May 20, 2015

Re: Durango at the Trails, Grading and Drainage Plan (C09/D012)

This letter provides a written response to your comments dated May 5, 2015:

DURANGO
UNIT 2
INTERIM GRADING AND DRAINAGE PLAN

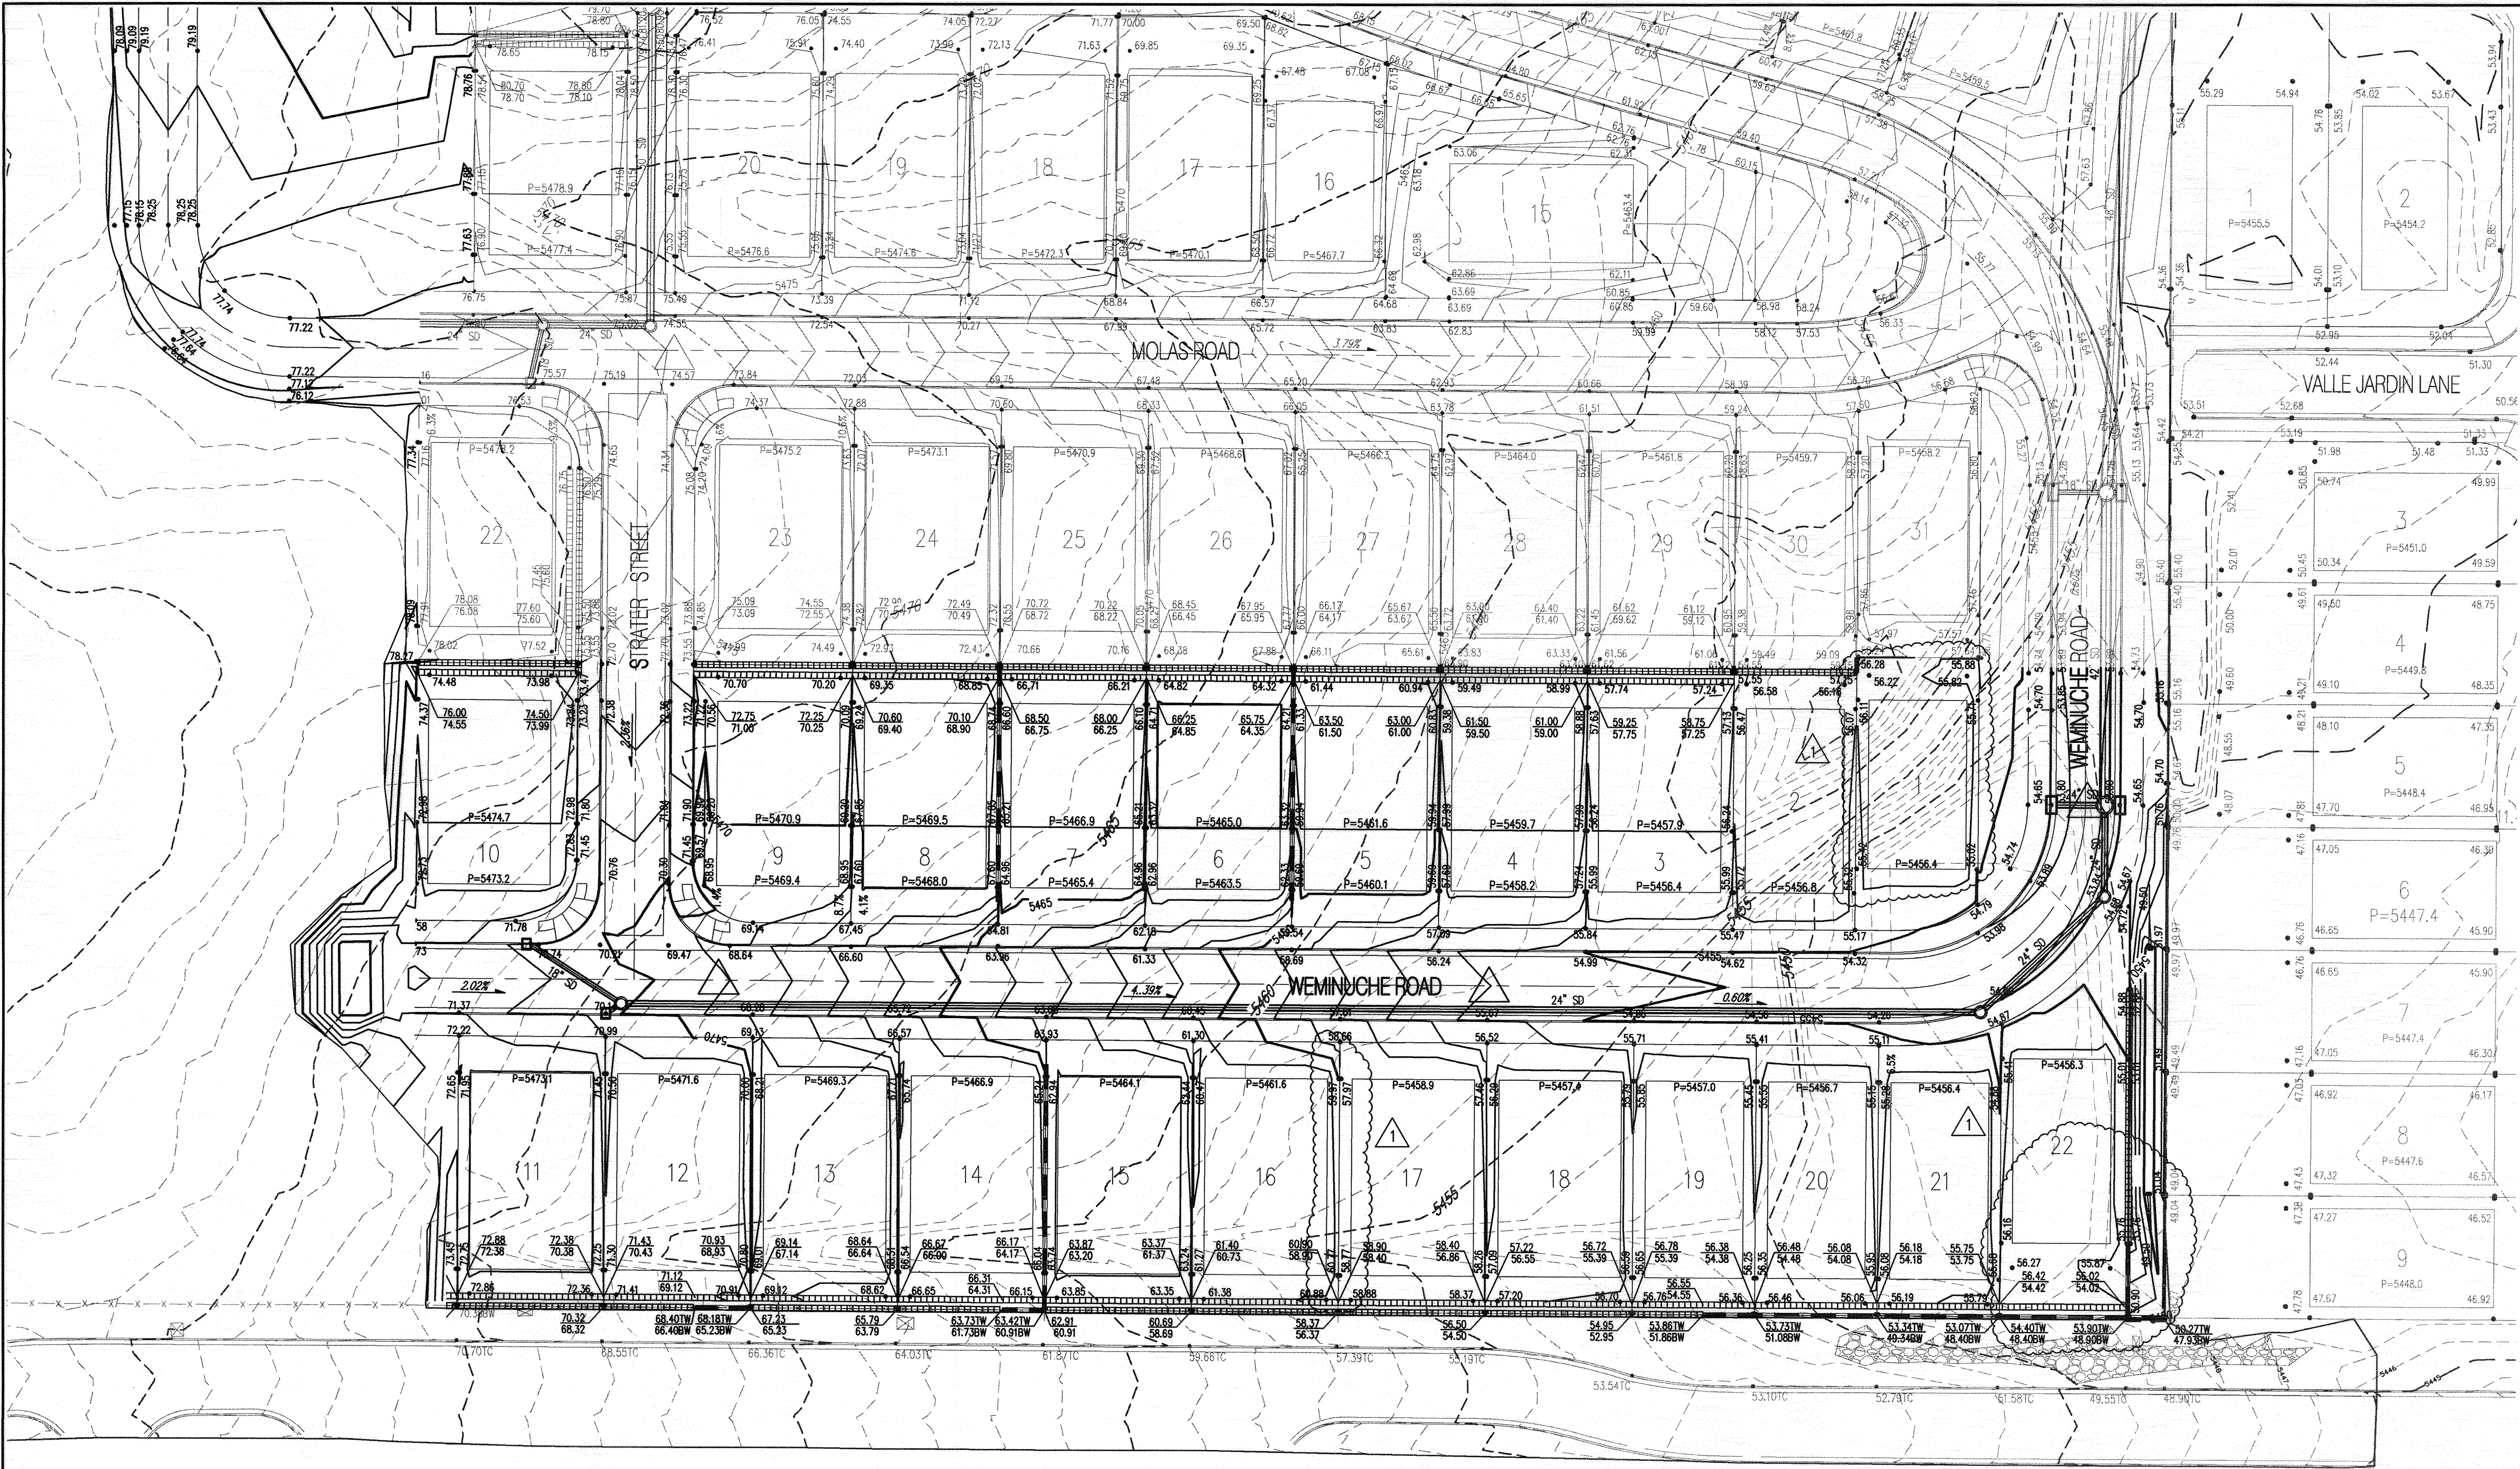
1. *Units 1 thru 4 are to be phased. Provide an interim grading plan for each phase, showing sediment ponds and tie slopes. **Interim grading plans are provided for Units 1 and 2. The tie slopes and sediment ponds for Units 3 and 4 are shown on the respective grading plans. At this point in time we are requesting preliminary plat approval of Units 1 and 2.***
2. *Provide revised grading plan showing recent changes. Grades and retaining walls will be checked after this plan is submitted. **Revised grading plan for Units 1 through 4 are provided.***
3. *Revise infrastructure list with separate line items for each run/size of pipe. **Infrastructure list has been revised per markup provided at 5/5/2015 meeting.***
